Recommendation Report for Planning Permission for Works or Extension to a Dwelling

REF NO: BR/136/20/HH

LOCATION: 19 Ivy Crescent
Bognor Regis
PO22 8AB

PROPOSAL: Single storey extension to front.

PROPOSED GROUND FLOOR PLAN

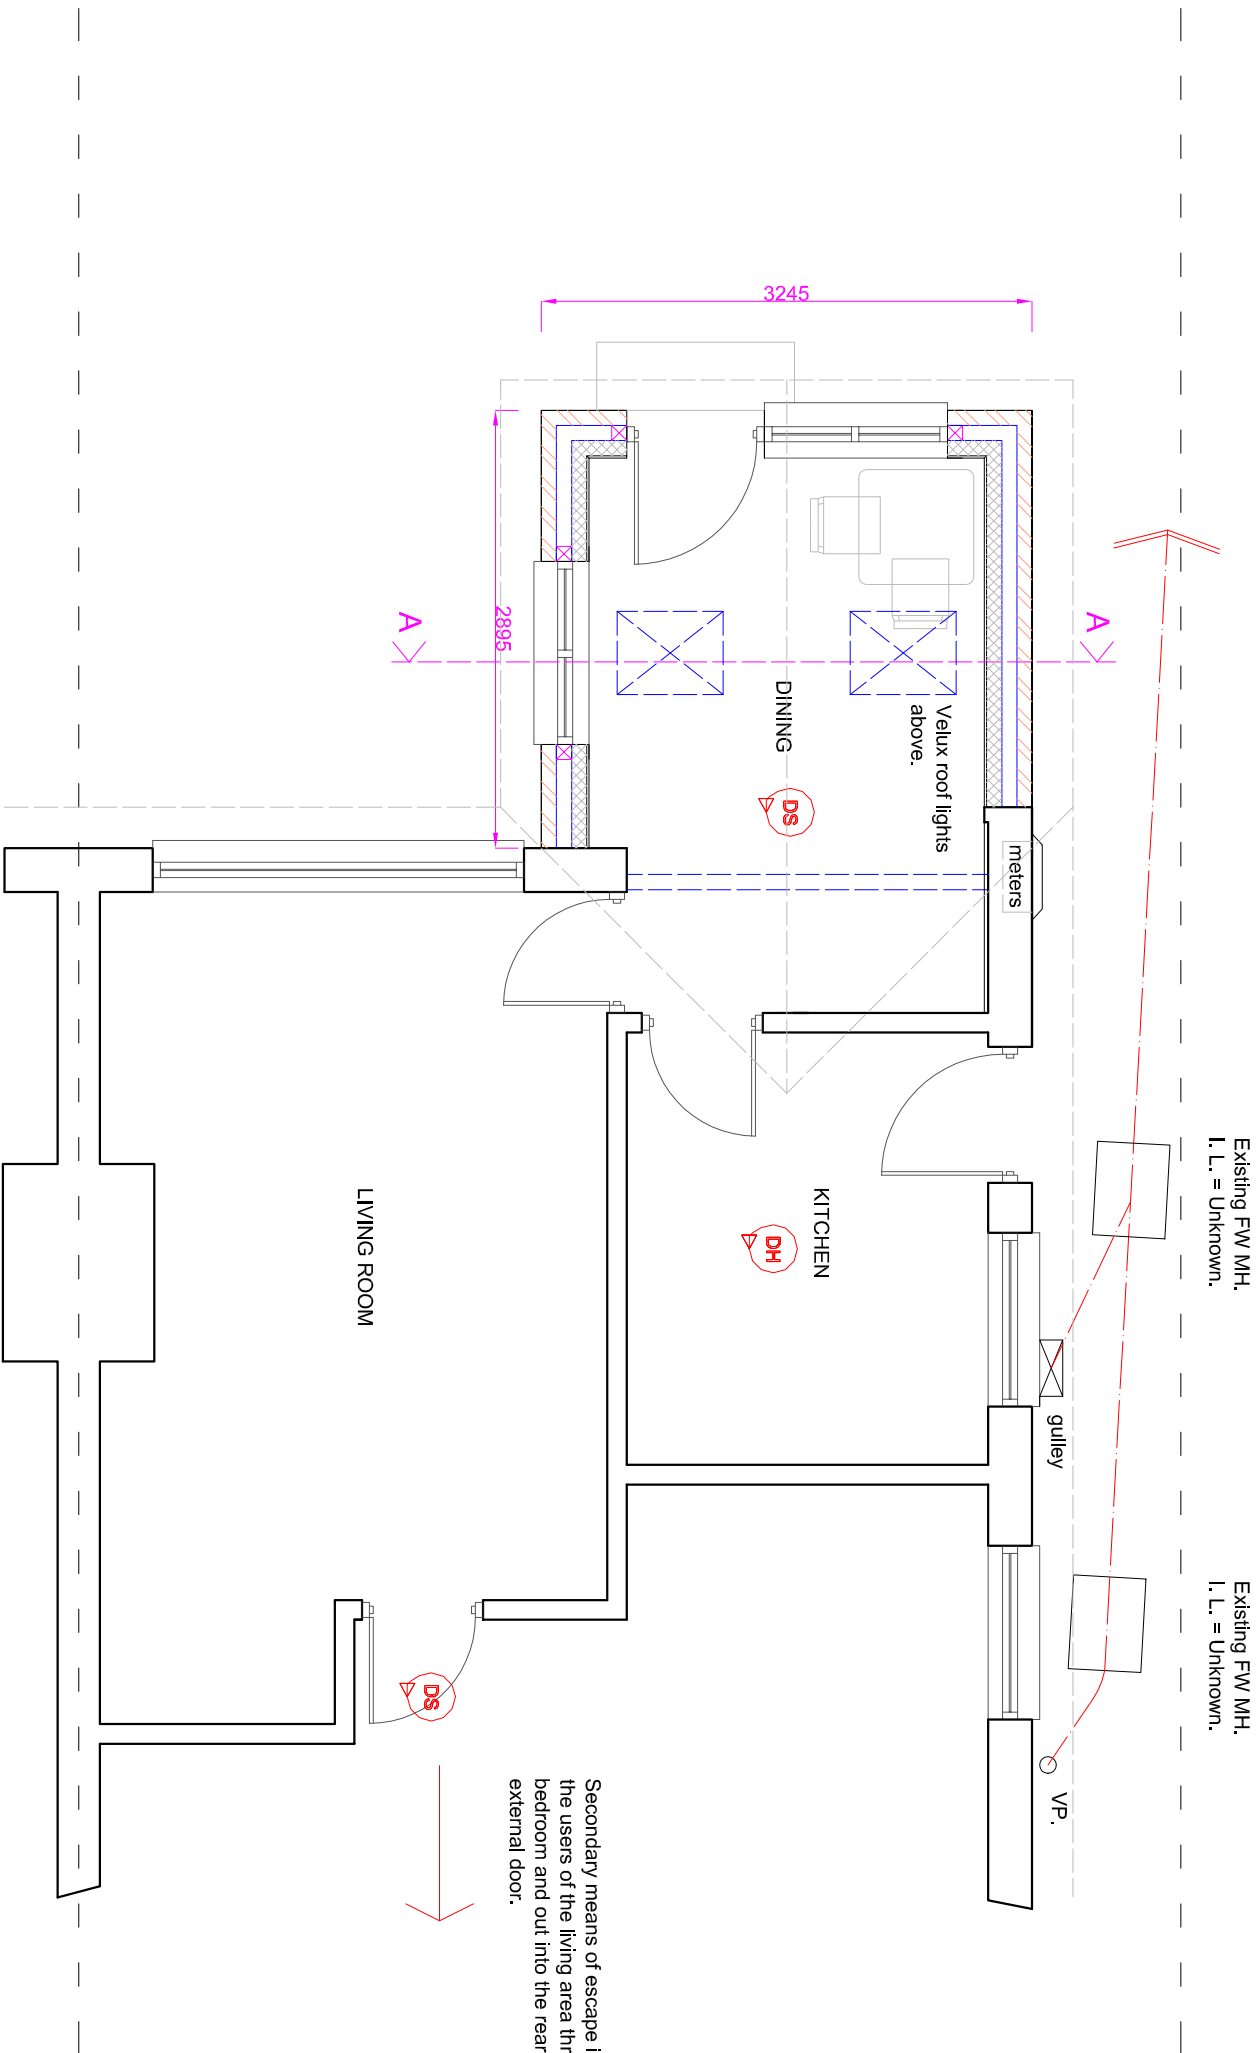
The extension increases the depth by around 1.6m compared to the existing porch and an increase in width by approximately 0.2m. However it is not considered to appear unduly dominant and does not extend beyond the property to the south west. It will have a height of 3.65m with eaves to 2.6m.

PROPOSED ELEVATIONS

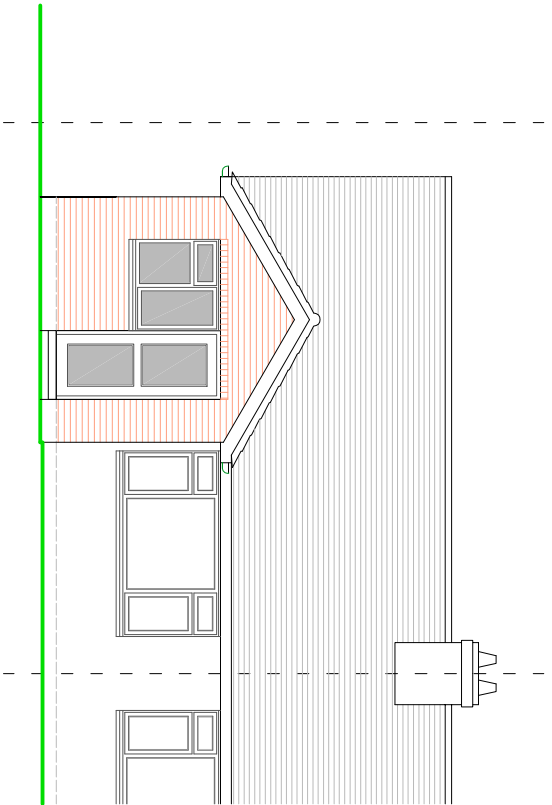
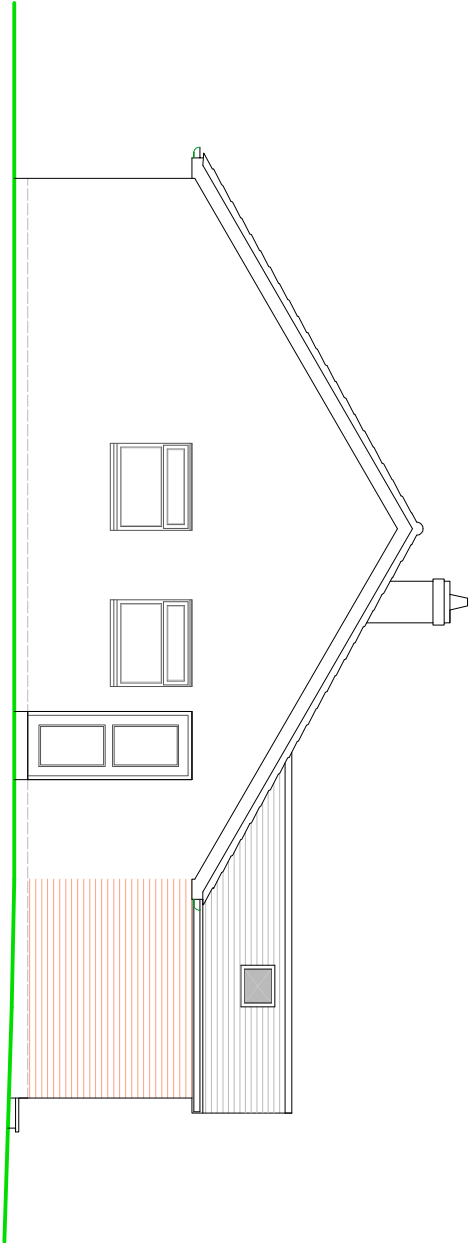
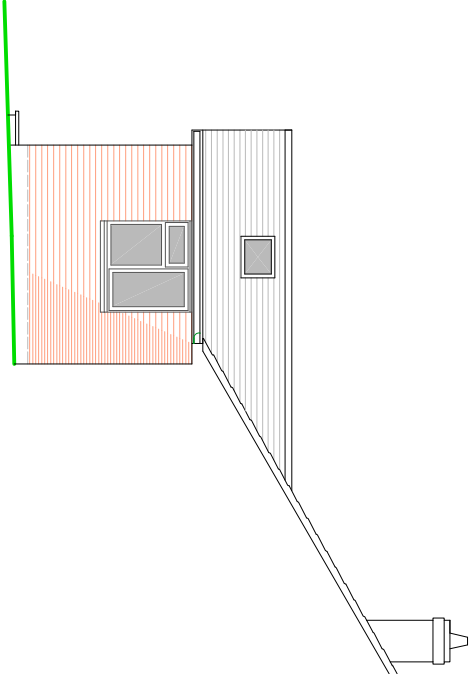
The surrounding area is similar in appearance with bungalows to one side of the road and two storey dwellings opposite. These predominately all consist of flat roofed porches to the front and therefore the addition is slightly out of character within the street scene, due to its design with a pitched roof. It is however not considered to provide such an adverse impact in which a refusal is justified.

Materials will match the host dwelling which helps to ensure it will appear well integrated.

With a door and window to the front, views will be of the street scene. There are also two rooflights proposed although due to the height above finished floor level are not considered to give rise to overlooking.
